Application by National Grid Electricity Transmission (NGET) for an Order Granting Development Consent for the Sea Link Project.

East Suffolk Council – Comments on the Schedule of ExA’s recommended amendments to the applicant’s draft Development Consent Order

Deadline 7 (29th April 2026)

ESC's comments on the Schedule of ExA's recommended amendments to the applicant's dDCO submitted at Deadline 6 [REP6-004] [PD-024]

Plate 2.1 Detail of updated HDD Conceptual Design in Sectional View showing exit position and depth below the eastern edge of the continuous Coralline Crag outcrop.

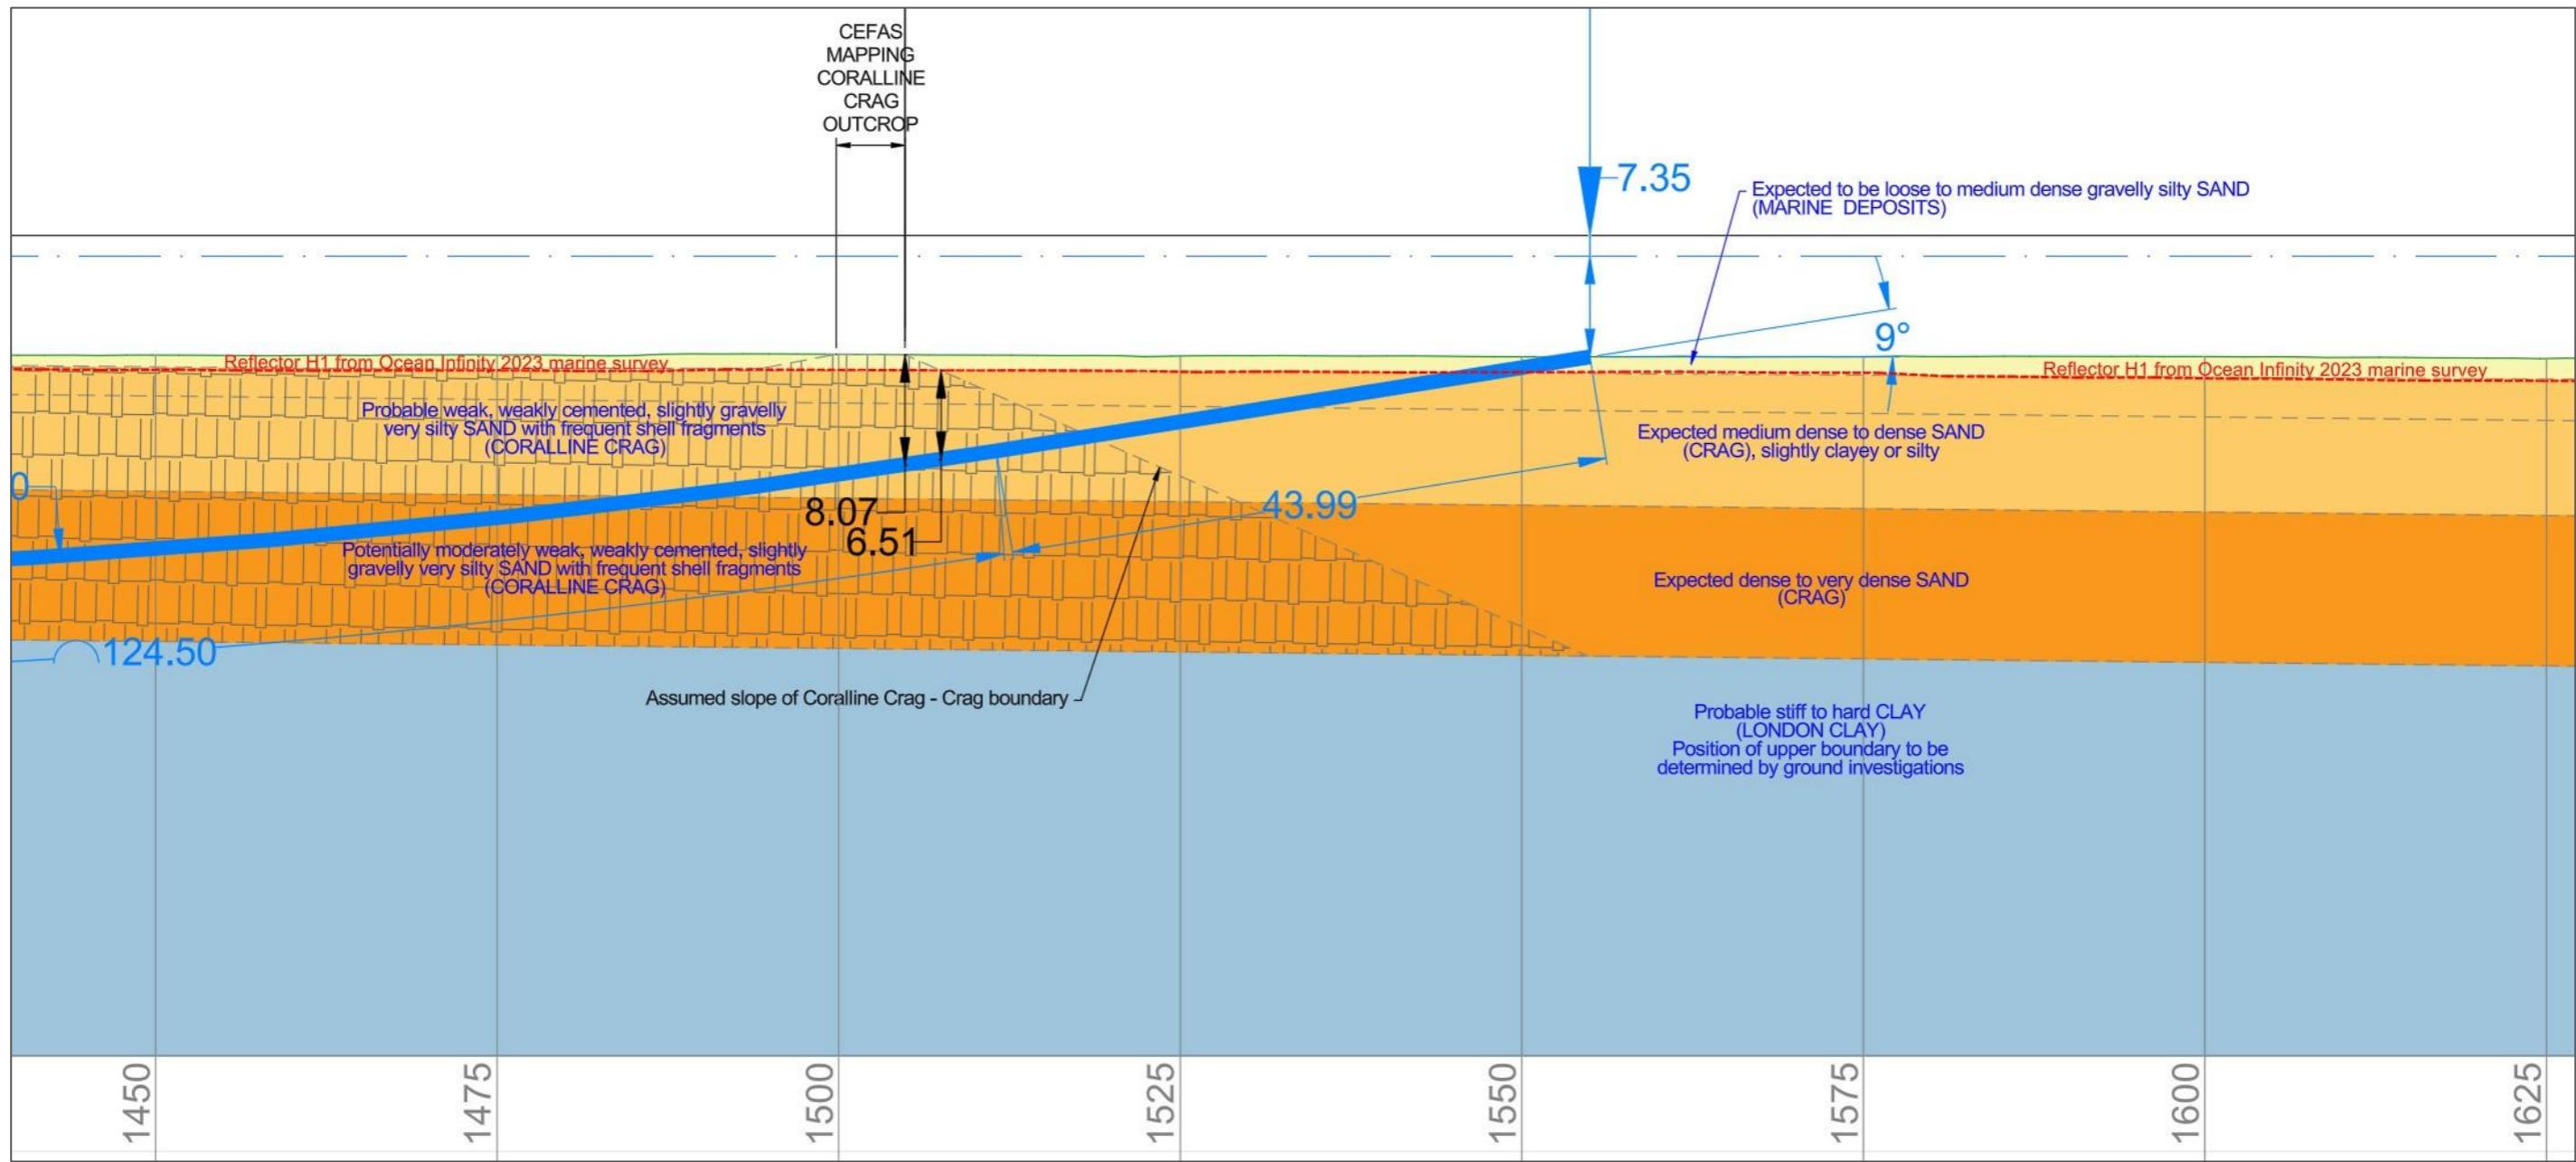
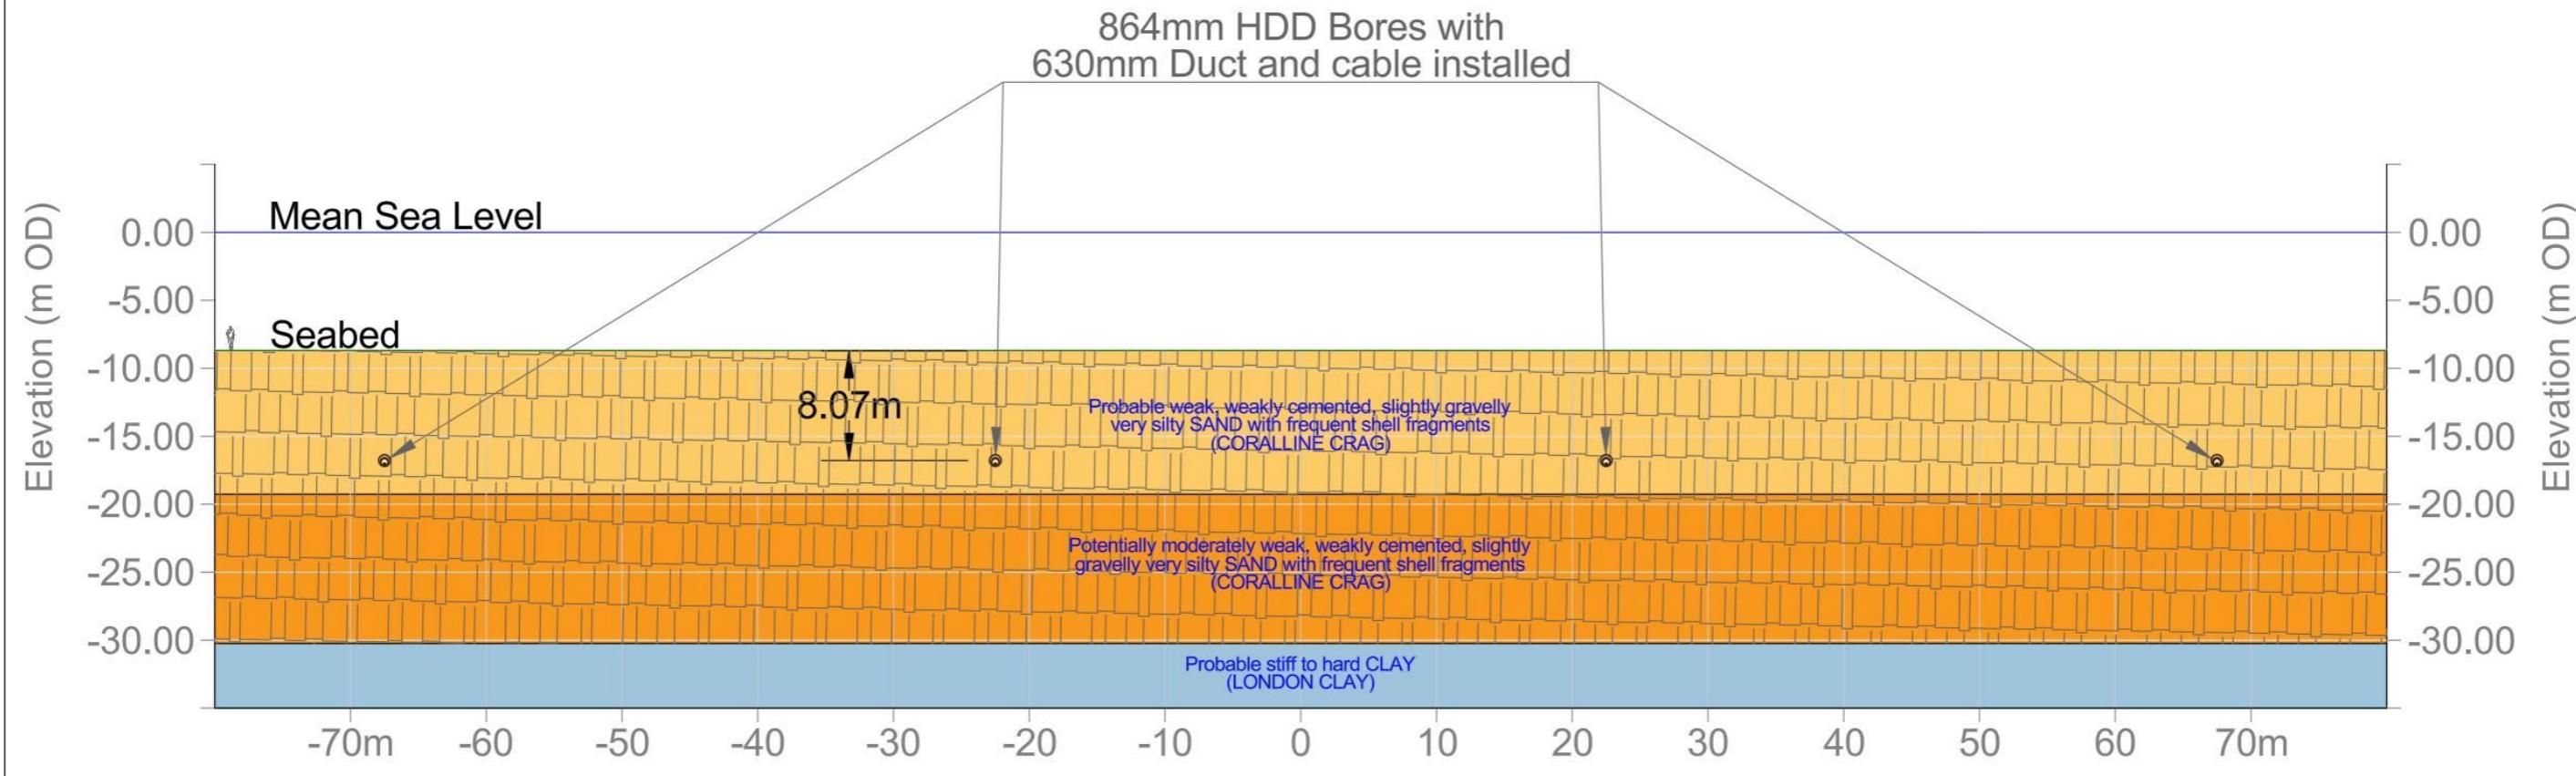
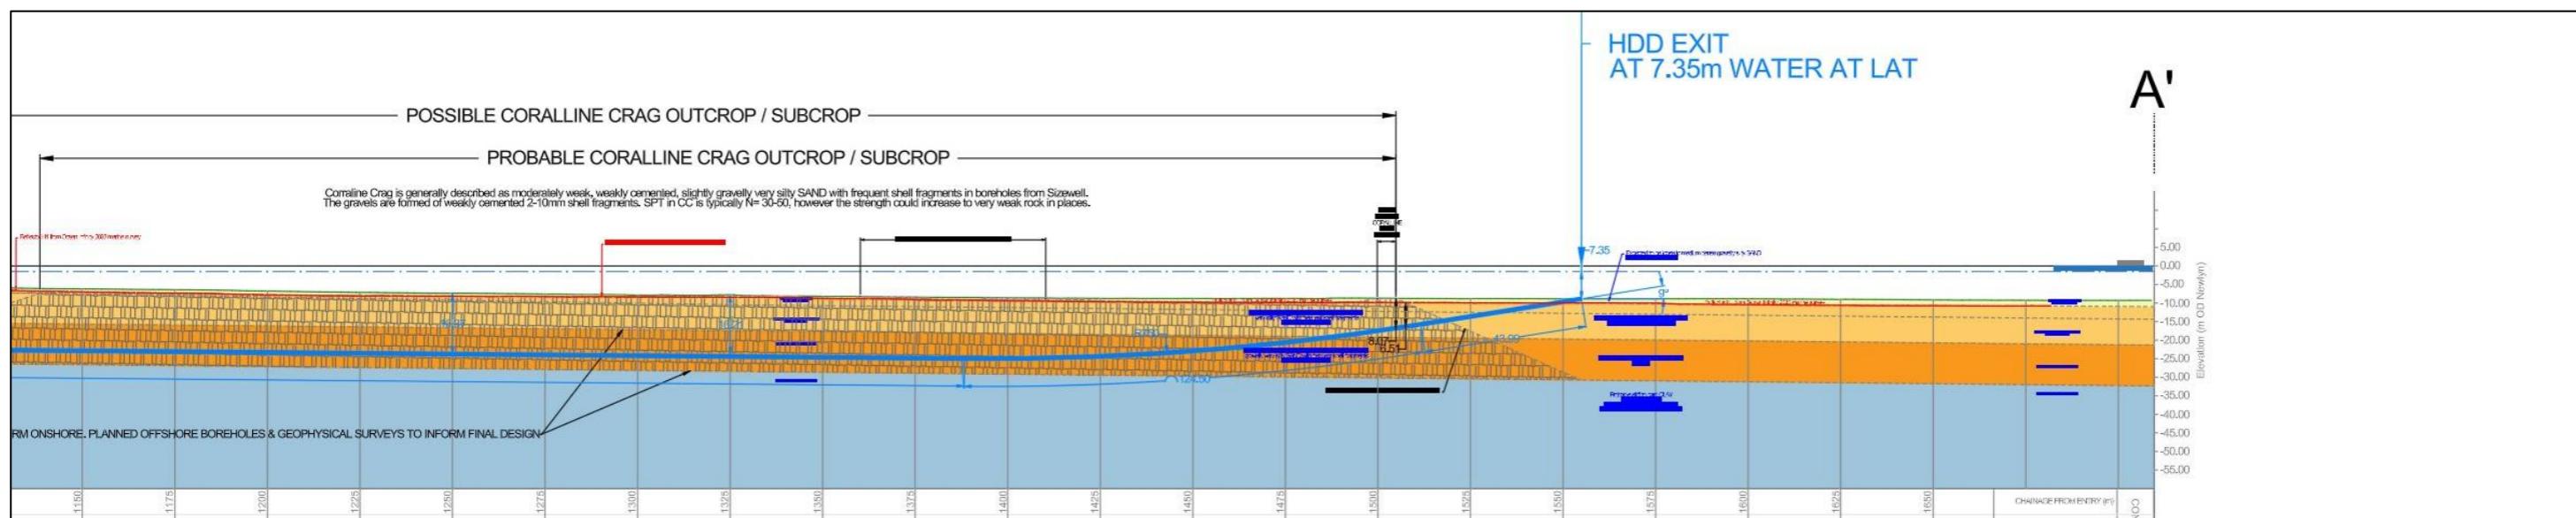
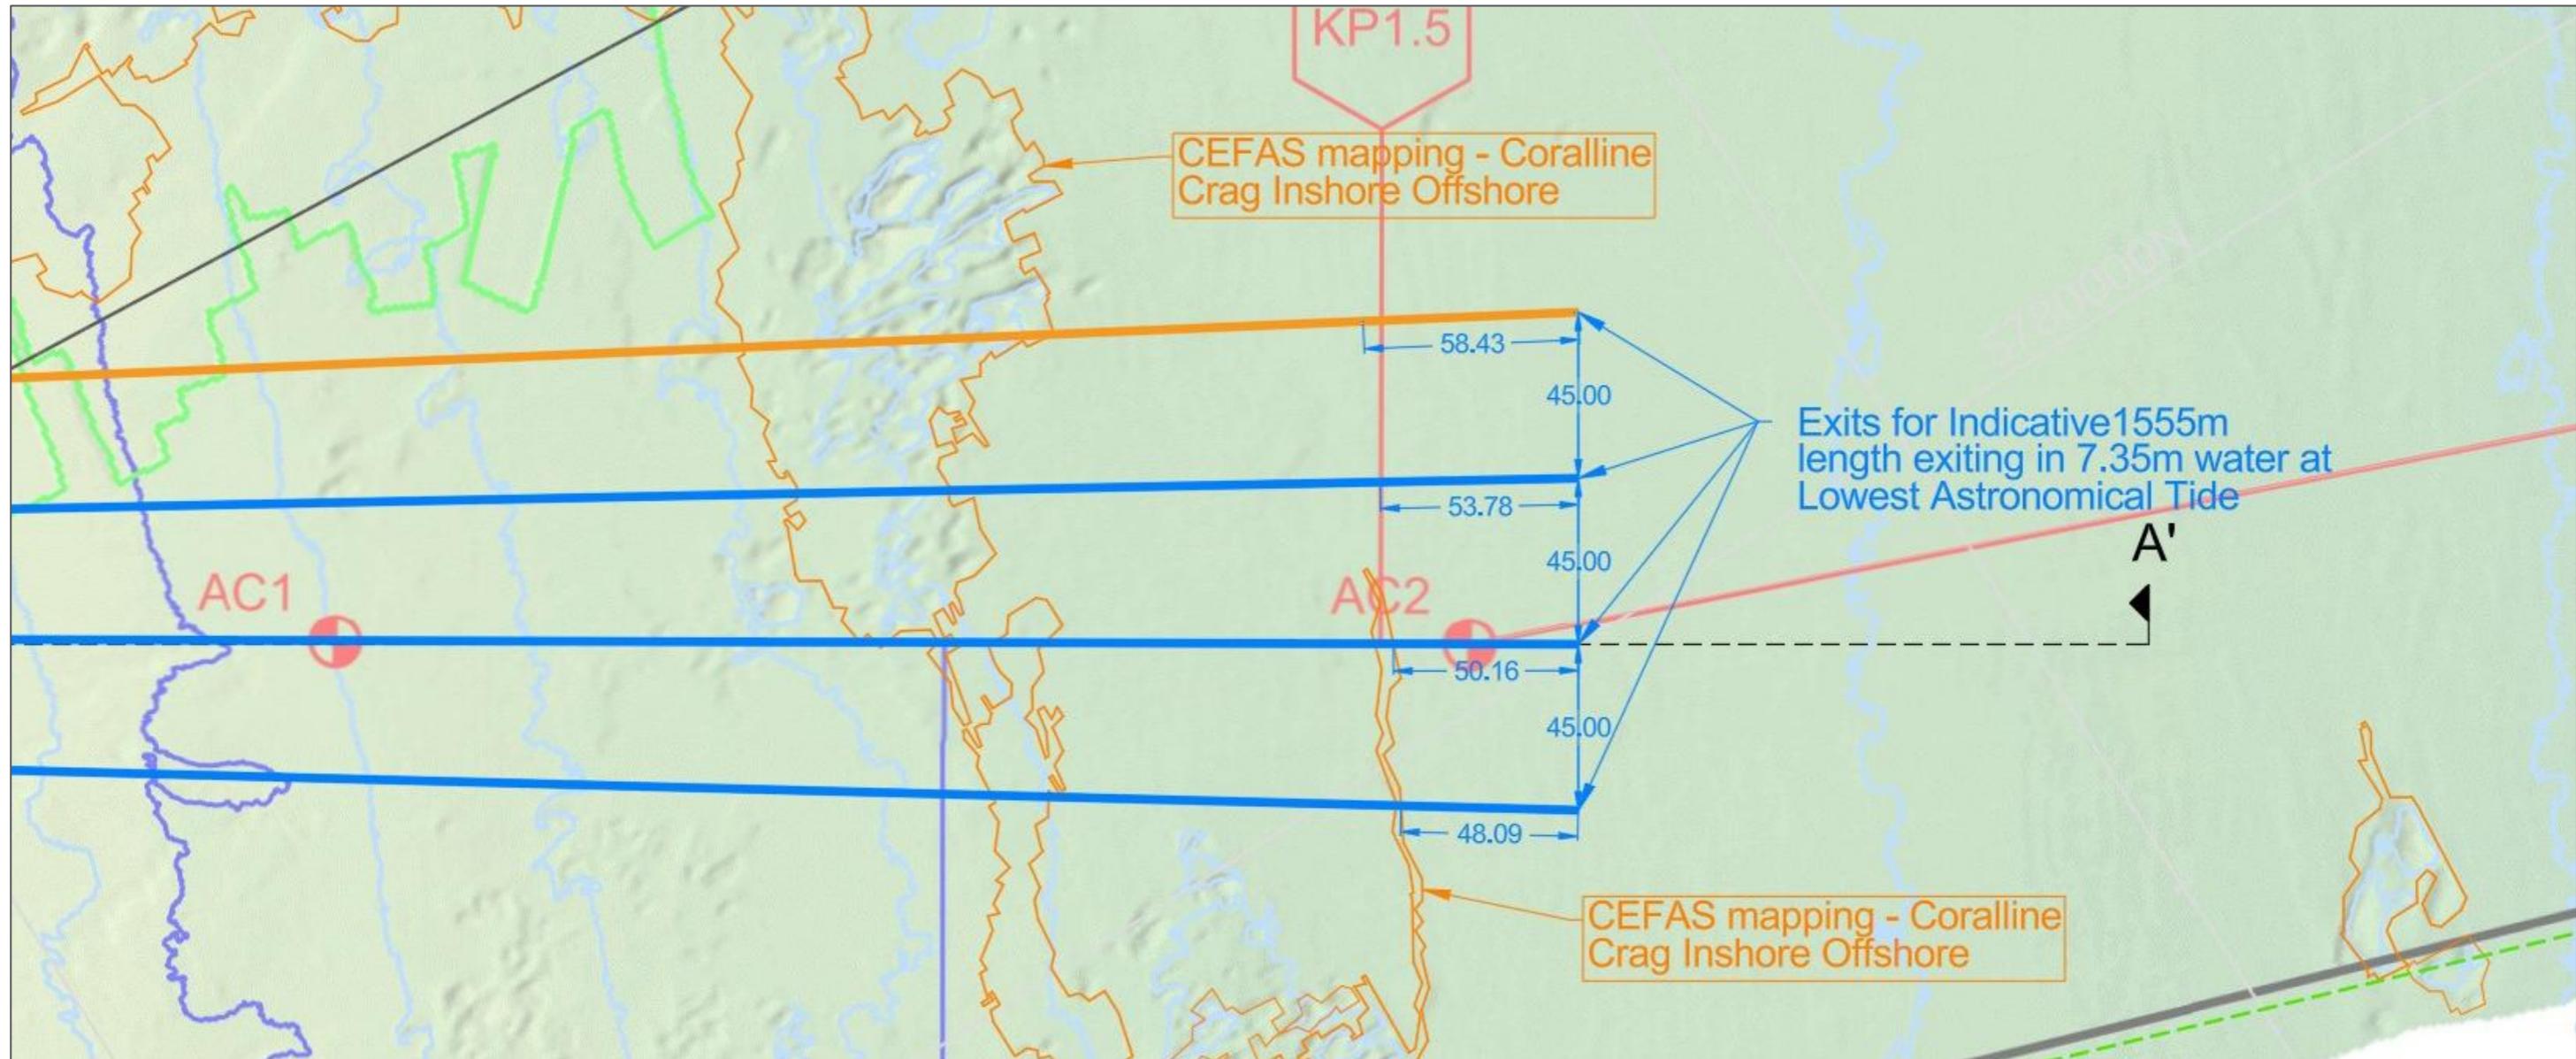
The ExA requested in ExQ2 Question 2GEN17 that the Applicant provide wording for a dDCO Requirement that would secure use of a trenchless landfall technique. The ExA noted that it *'may also provide for a minimum depth of burial to address concerns regarding coastal erosion'*. However, Requirement 16 of the draft DCO as currently drafted, does not secure a minimum depth of burial, nor does the ExA's recommended amendments to Requirement 16 seek to secure this. In response to ExQ2 Question 2GEN17, ESC provided its proposed wording for a dDCO Requirement to secure the submission of a landfall construction method statement and landfall monitoring plan to ESC for approval post-consent [REP5-189]:

(a) a landfall construction method statement for the construction of that part of Work No. 6. This must secure use of the specific trenchless landfall technique and include the final proposed profiles for the trenchless cable burial, demonstrating a minimum cable burial depth of 25m below the contemporary foreshore elevation; and

Therefore, whilst ESC welcomes the ExA's recommended changes to Requirement 16 of the draft DCO to ensure that exit to the trenchless landfall techniques occurs at least 45m east of the continuous Coralline Crag outcrop, to prevent use of pneumatic casing without prior approval from the Marine Management Organisation, and to prevent open cut trenching for maintenance and repair, ESC maintains its request for the detail set out in its proposed Requirement above to also be incorporated into Requirement 16. This includes committing the undertaker to submitting a landfall construction method statement and landfall monitoring plan, and to a 25m cable burial depth beneath the foreshore level (as shown on the landfall design drawing in Application Document 7.3 Design Development Report – Appendix A Landfall HDD Feasibility Technical Note [APP-321] page 99). There is precedent for such a DCO Requirement, with SPR's EA1N and EA2 projects including Requirement 13 (Landfall construction and method statement and monitoring plan). Due to the well-known erosion issues along the Suffolk coast, ESC considers such a Requirement essential for all projects making landfall in Suffolk. The erosion rates currently experienced at Thorpeness, adjacent to the landfall site, have already exceeded the NCERM2 forecast up to year 2055, and therefore ESC must take a precautionary approach to anticipating future coastal change, because the historical data available is not representative of the current situation.
